Your Ref: OWPC20742
Our Ref: BR/283/18/PL 05-11-2018
Please ask for:
Mr S Davis

Enlarge dormer to the bay roof on north elevation. Ground floor windows & doors & railings to west elevation. This application affects the character & appearance of The Steyne, Bognor Regis Conservation Area.

Central House 18 Waterloo Square Bognor Regis

Thank you for your internet representation made on 28th November 2018 which has been recorded as '**an objection**' with the comments as follows:

PROPOSED NORTH ELEVATION

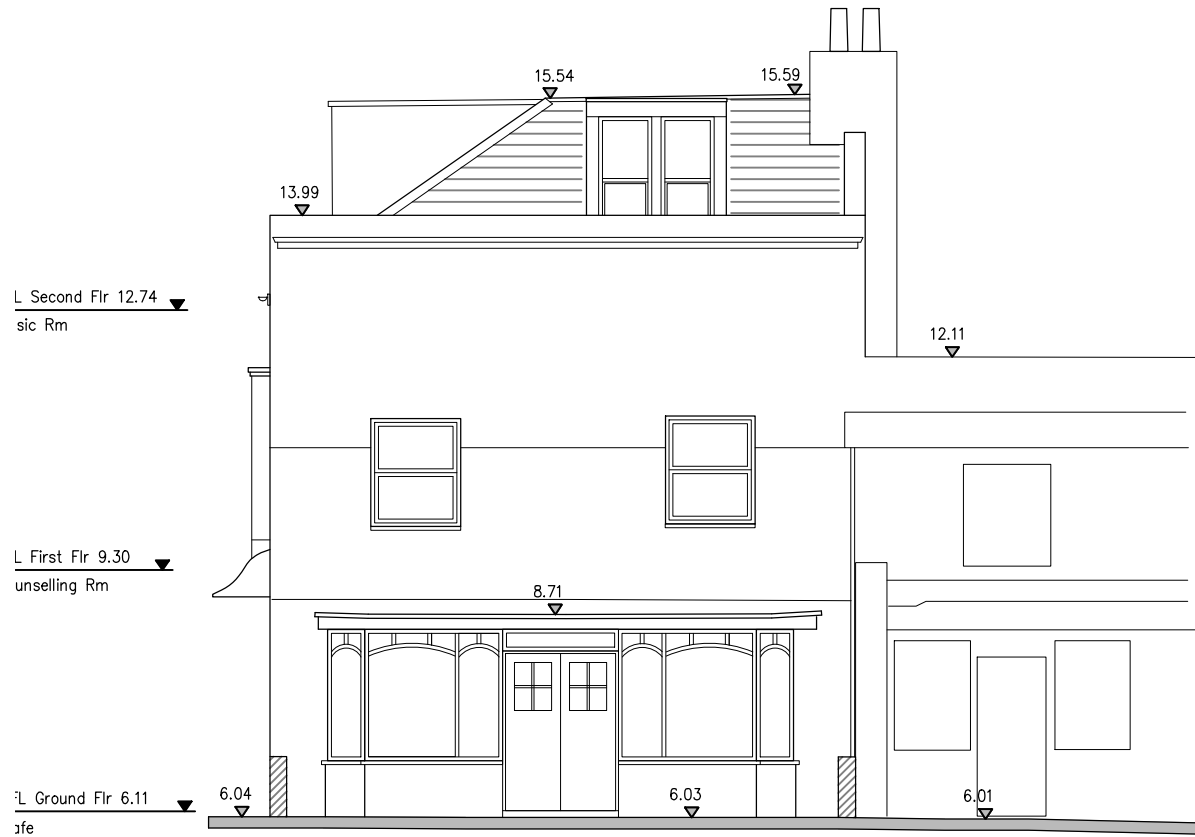
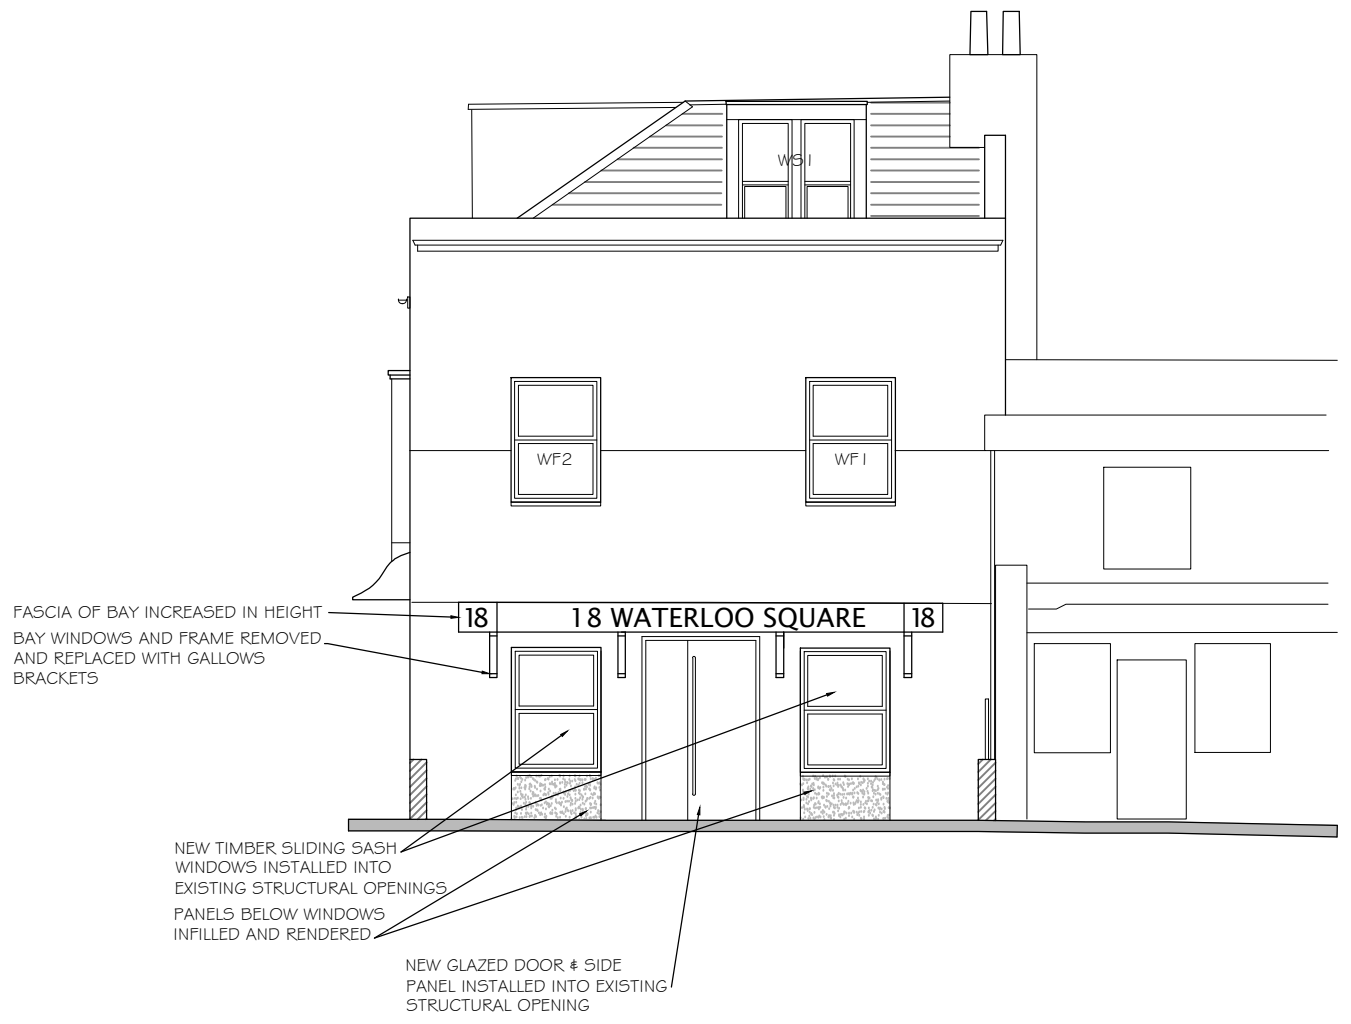
One of the areas of the external alterations that concerns me is the bay roof, referring directly to the proposals I quote "The bay roof would be increased in height to match the neighbouring Waterloo Inn." The desire to provide consistency with a neighbouring building would clearly go against, and be in stark contrast to the existing character of the Conservation Area.

It is clear removal of the buildings most striking asset, this being the front door and bay window would adversely affect both the appearance of the building and on a wider scale the setting of the building.

PROPOSED WEST ELEVATION

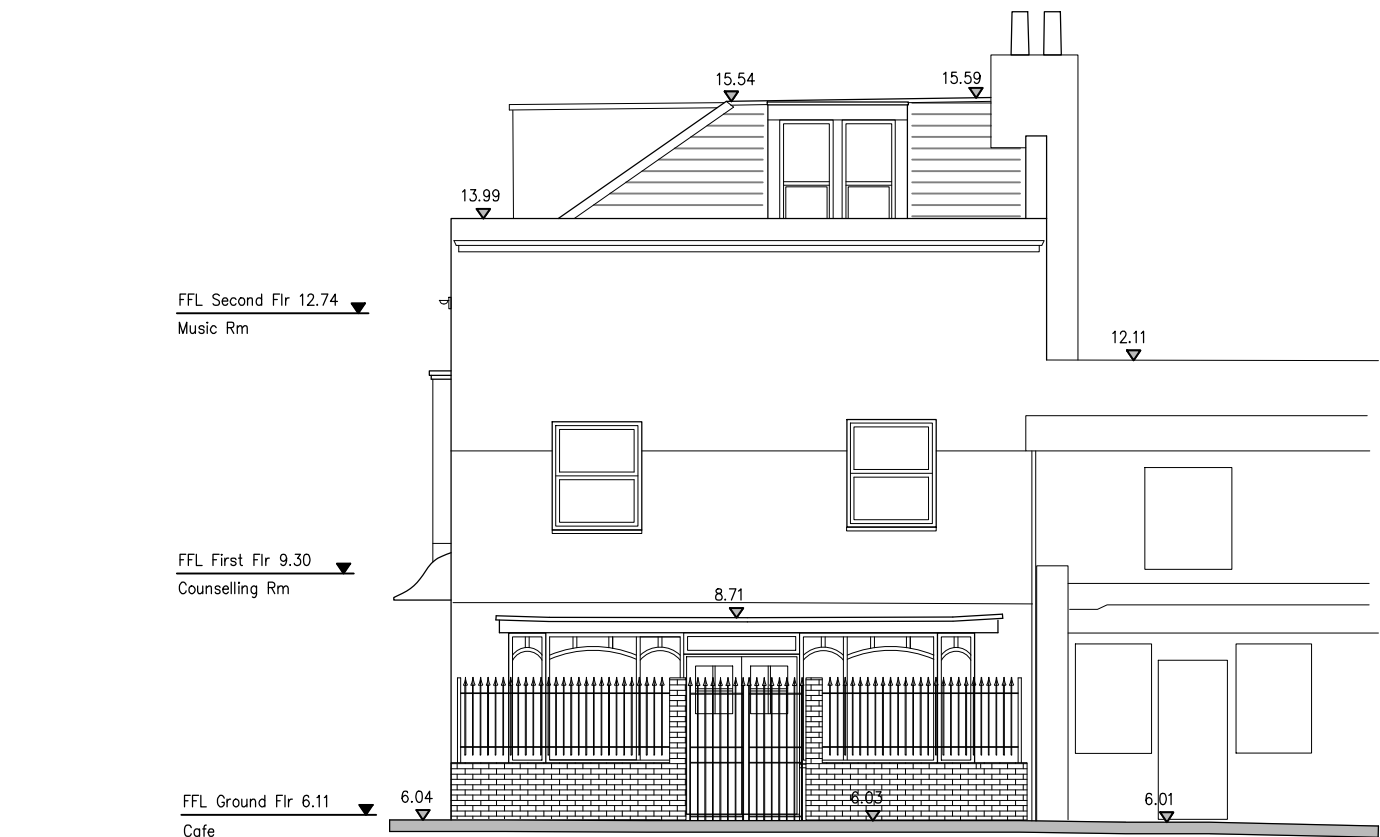
I also find the proposals for the main front door "to be plate glass with a glass side panel"

wholly inappropriate for a building of this age, especially considering its setting.

Whilst I welcome investment in this area and support the aim in making this building more attractive to prospective tenants there is nothing in these plans to justify the alterations to the front door, removal of the bay window and the attempt to provide a consistent external appearance with the neighbouring property.
